Application by Aquind Limited for a Development Consent Order for the 'Aquind Interconnector' electricity line between Great Britain and France (PINS reference: EN020022)

Development Consent Protective Provisions in relation to Little Denmead Farm

On behalf of

Submitted in relation to Deadline 8 of the Examination Timetable

APPENDIX 2
PLAN 1 & PLAN 2

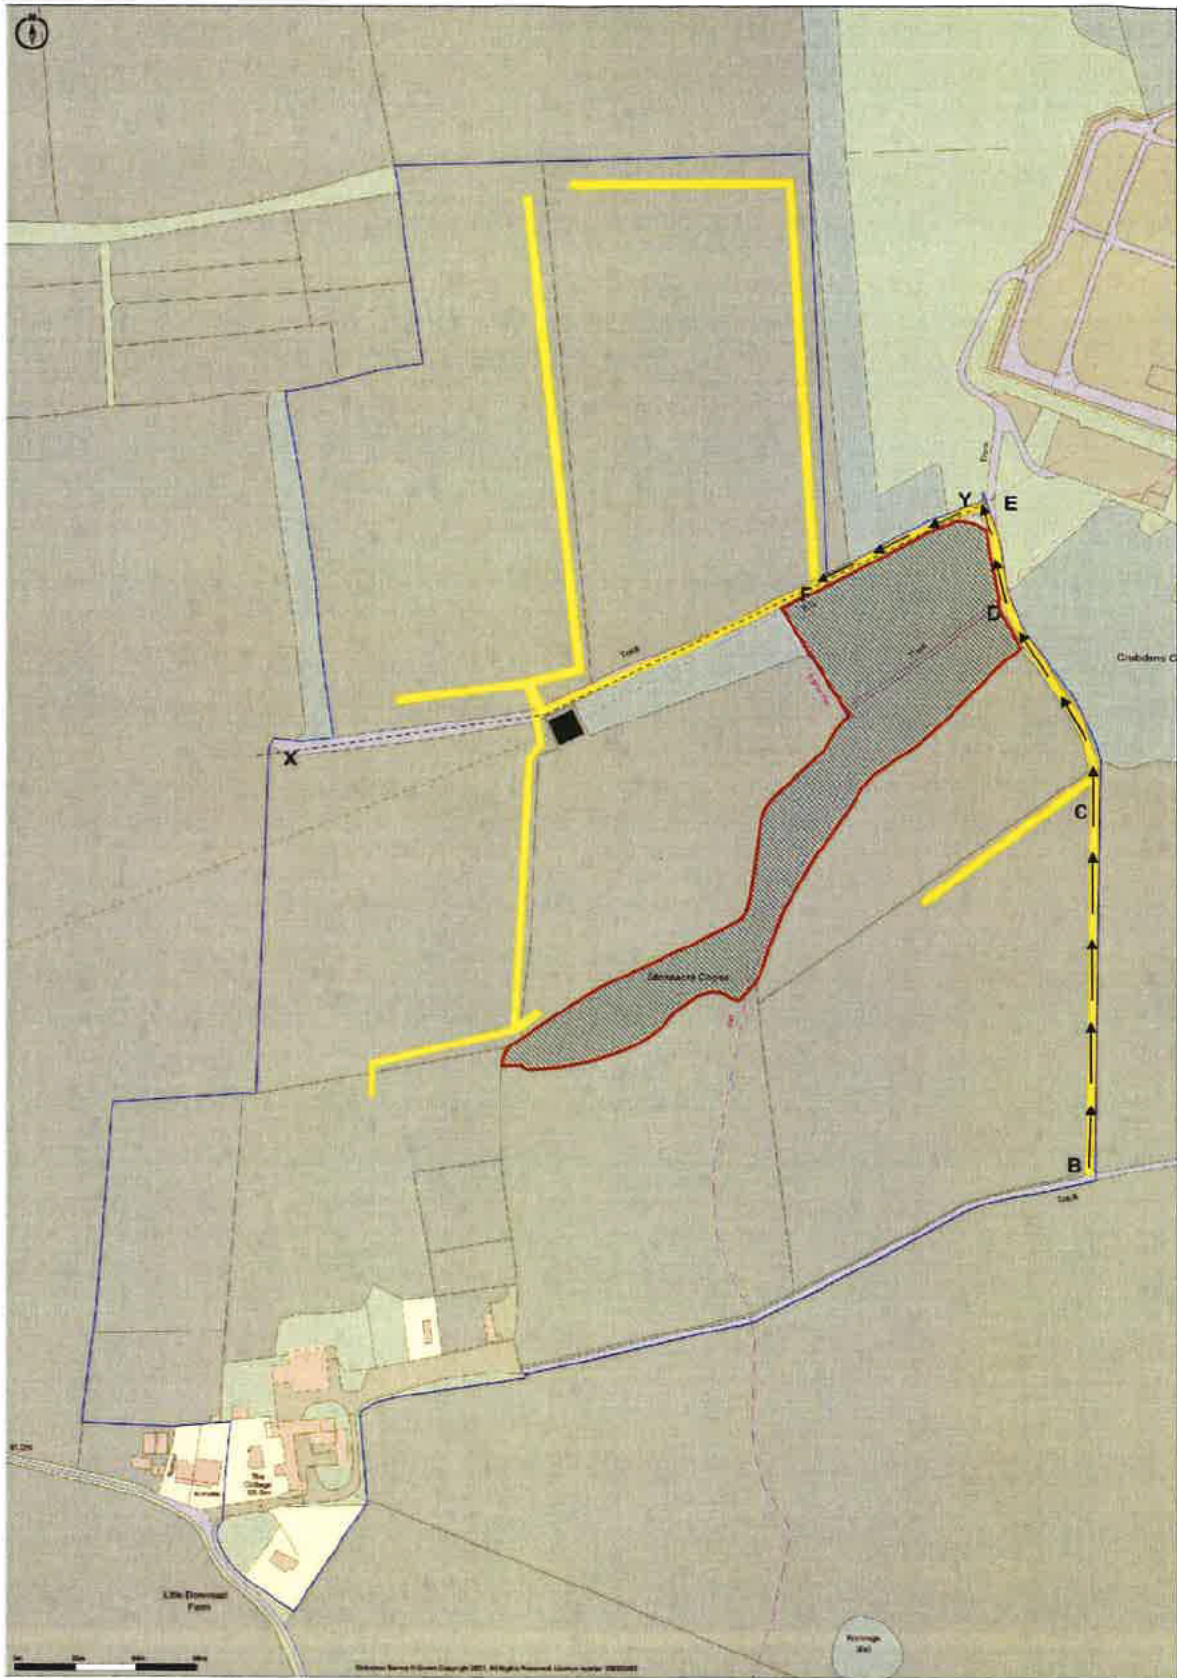
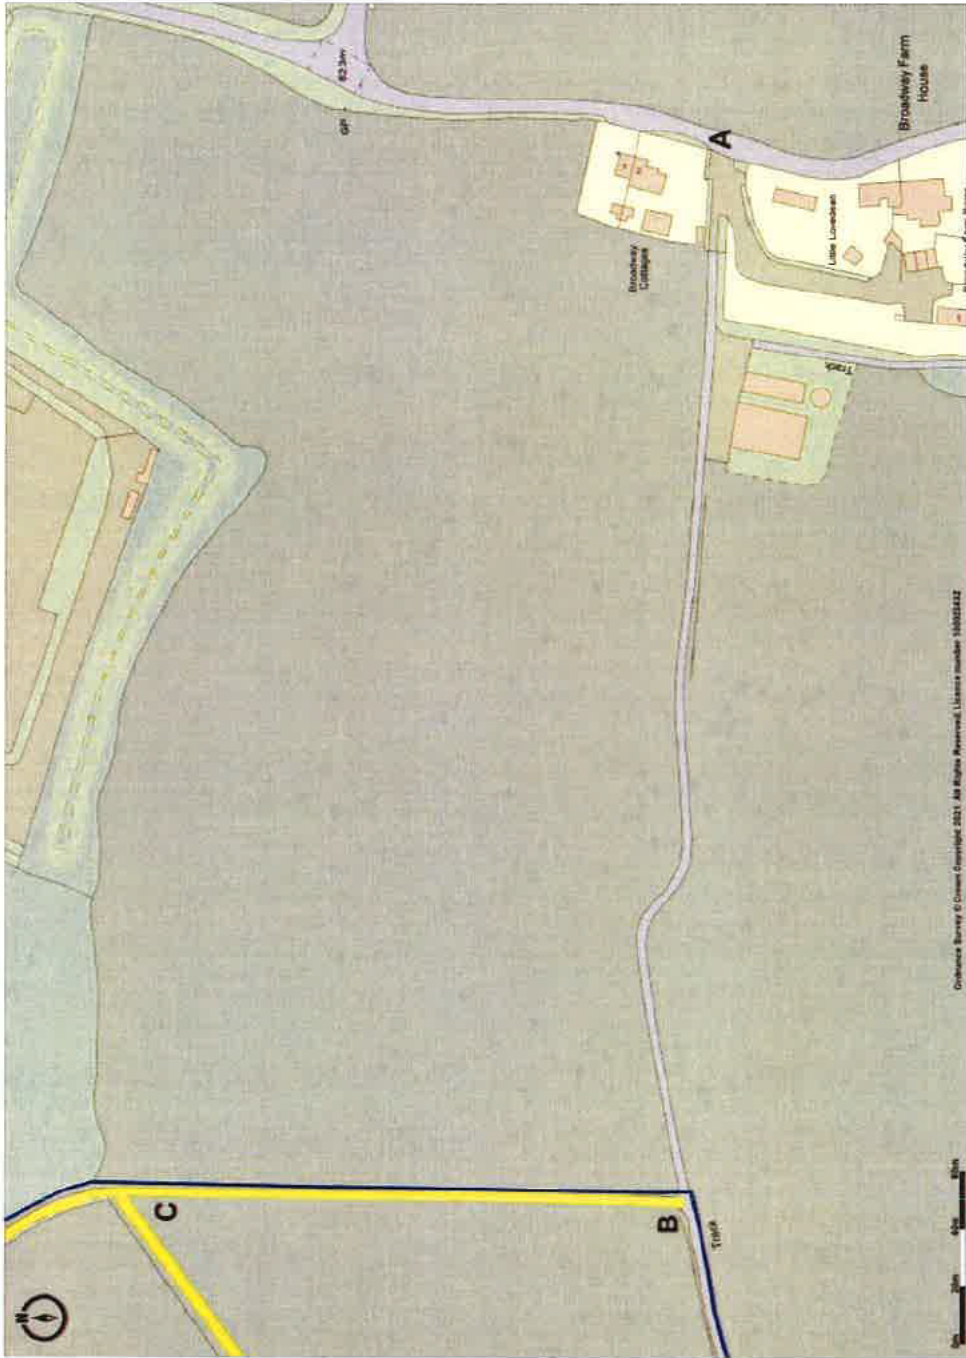
20. Please see the image below. The Affected Party proposes that the Applicant only be allowed to compulsorily acquire its freehold interest to all the land to the north of the northern most edge of the access track coloured yellow, with such access track being shown approximately running on the land between points 'X' and 'Y' on the plan below. For clarity, the plan below includes yellow strips north of this line which are existing tracks referred to in a licence agreement but are not relevant here.

21. This would provide the Applicant with sufficient land on which to construct the converter station, security fencing and also leave enough land on which to have permanent landscaping on the converter station's southern most fringes.
22. This would also enable the Applicant, as a result of the Affected Party's unilateral DCO Obligation, to construct an alternative access from the bottom left hand corner of the converter station to meet the alternative access route the Affected Party has offered under the DCO Obligation (the alternative access route under the DCO obligation runs from points B to F on the image above and is shown marked with

black arrows). Alternatively, this could allow an access way from indicative location shown on the converter station plan southwards and then eastwards to the alternative access way (for the avoidance of doubt the existing track coloured yellow running between points X and Y remains in the Carpenters' freehold ownership). This allows the Applicant to take the maintenance access track from any point along the existing to the southern most fringes of the converter station. This in itself would allow the Applicant access into the converter station throughout its operational life.

"Landscaping Area of the Affected Property" means the extent of the area of ground shown on The Plan comprising the area north of the northern most edge of the existing access track coloured yellow, such existing access track being shown approximately running on the land between points 'X' and 'Y' on The Plan;

“The Plan” means the plan identified as the "Accessway Plan – Plan 1 of 2' and showing a route identified by black arrows showing an access way between points B and F, which accessway remains in the freehold title of Little Denmead Farm, together with the remainder of the access way in the westward direction therefrom running West to East between points X and Y, and identifying the said accessway from the northern most side of which accessway is land able to be compulsorily acquired under para 3 of this part 7, and certified in Schedule 14. **[See the Plan appended to [REP7-119]]**.
